APPLICATION NO. 03DRB - 01296	PROJECT NO. 1002859
PROJECT NAME Anderson Addn	8A
EPC APPLICATION NO.	
APPLICANT / AGENT Philip Turner	PHONE NO. 884-9087
ZONE ATLAS PAGE 514	
(SDP for SUB), (SDP for BP), (FINAL PLATS), (MASTER DEV PLAN) (IR) (AA)	
<b>ONE STOP COMMENT FORM LOG</b>

DRB-1002859

**RE: Anderson Addition, Lots 8-11, Block 3**

PLAT OF LOT 8-A, BLOCK 3  
**ANDERSON ADDITION**  
 SITUATE WITHIN  
**PROJECTED SECTION 17**  
**T.10N., R.3E., N.M.P.M.**  
**TOWN OF ALBUQUERQUE LAND GRANT**  
**CITY OF ALBUQUERQUE**  
**BERNALILLO COUNTY, NEW MEXICO**  
 JULY 2003

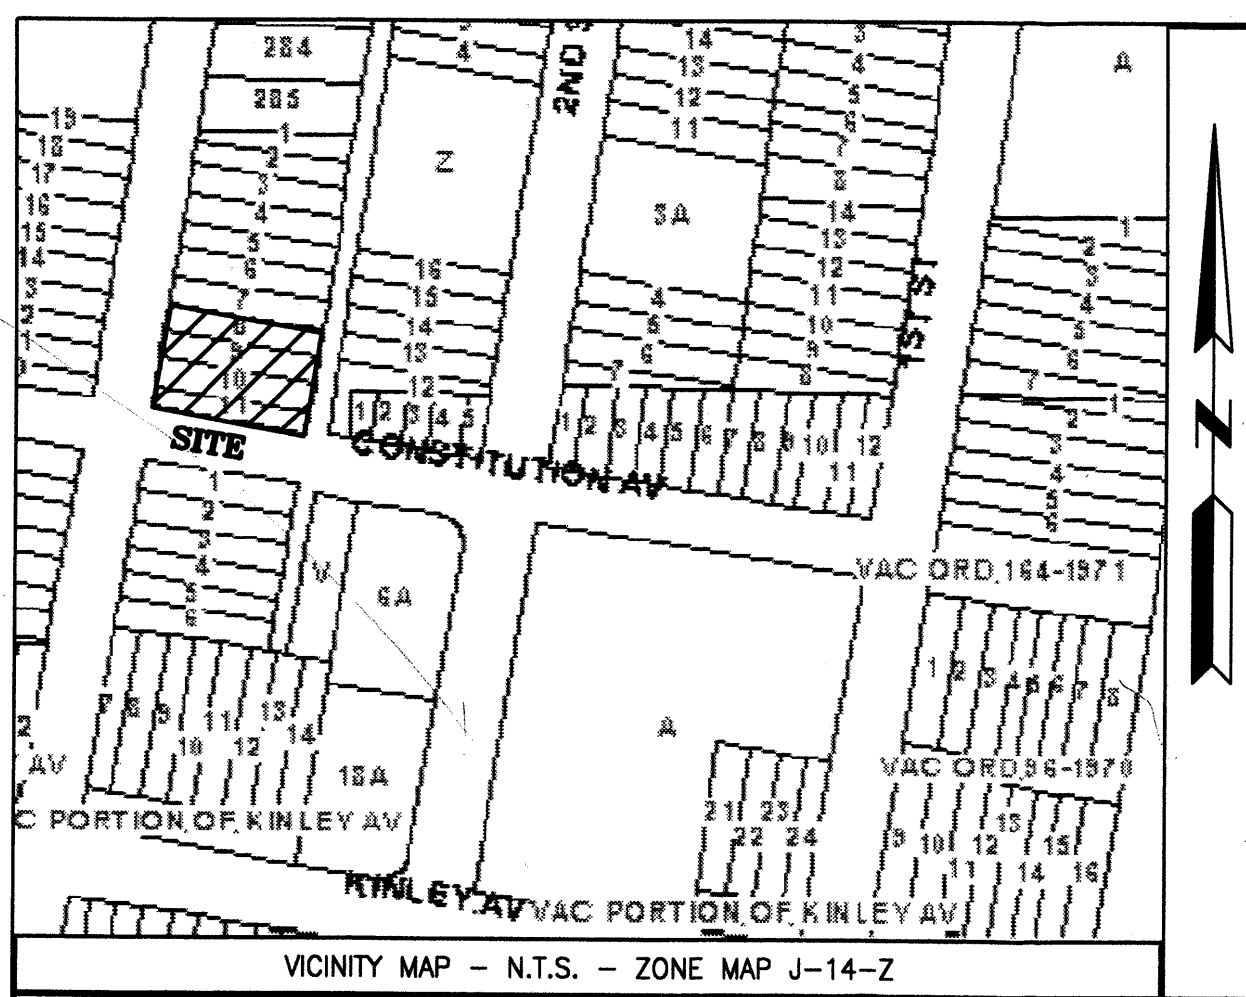
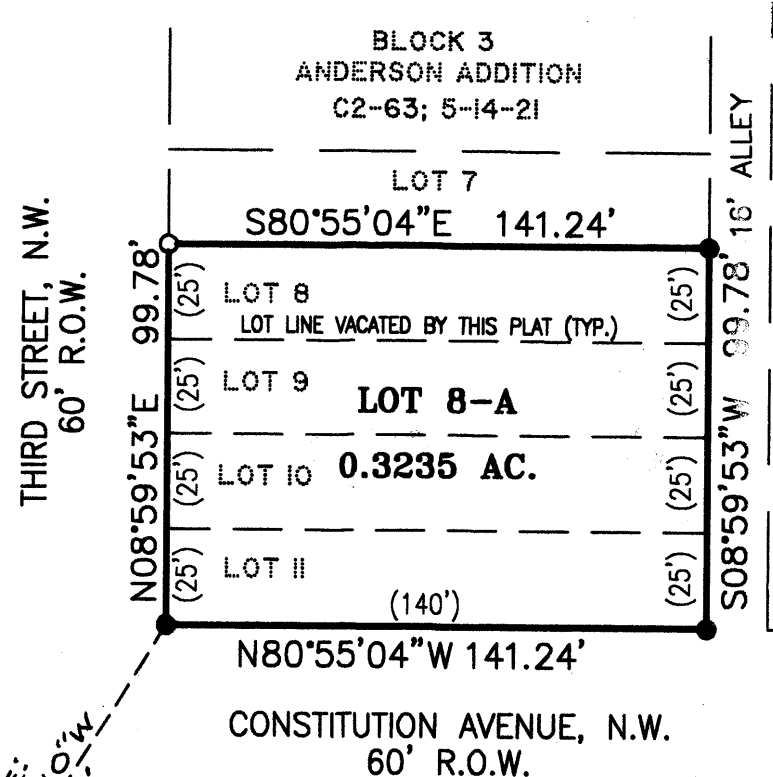
- TRANSPORTATION:
  - alley
  - curve radii
  - \_\_\_\_\_
  - \_\_\_\_\_
- UTILITIES:
  - \_\_\_\_\_
  - \_\_\_\_\_
  - \_\_\_\_\_
  - \_\_\_\_\_
- CITY ENGINEER / AMAFCA:
  - \_\_\_\_\_
  - \_\_\_\_\_
  - \_\_\_\_\_
  - \_\_\_\_\_
- PARKS / CIP:
  - \_\_\_\_\_
  - \_\_\_\_\_
  - \_\_\_\_\_
  - \_\_\_\_\_

No.	Comment
<input type="checkbox"/>	A 15ft radius is needs to be dedicated at the intersection.
<input type="checkbox"/>	Is the alley paved?
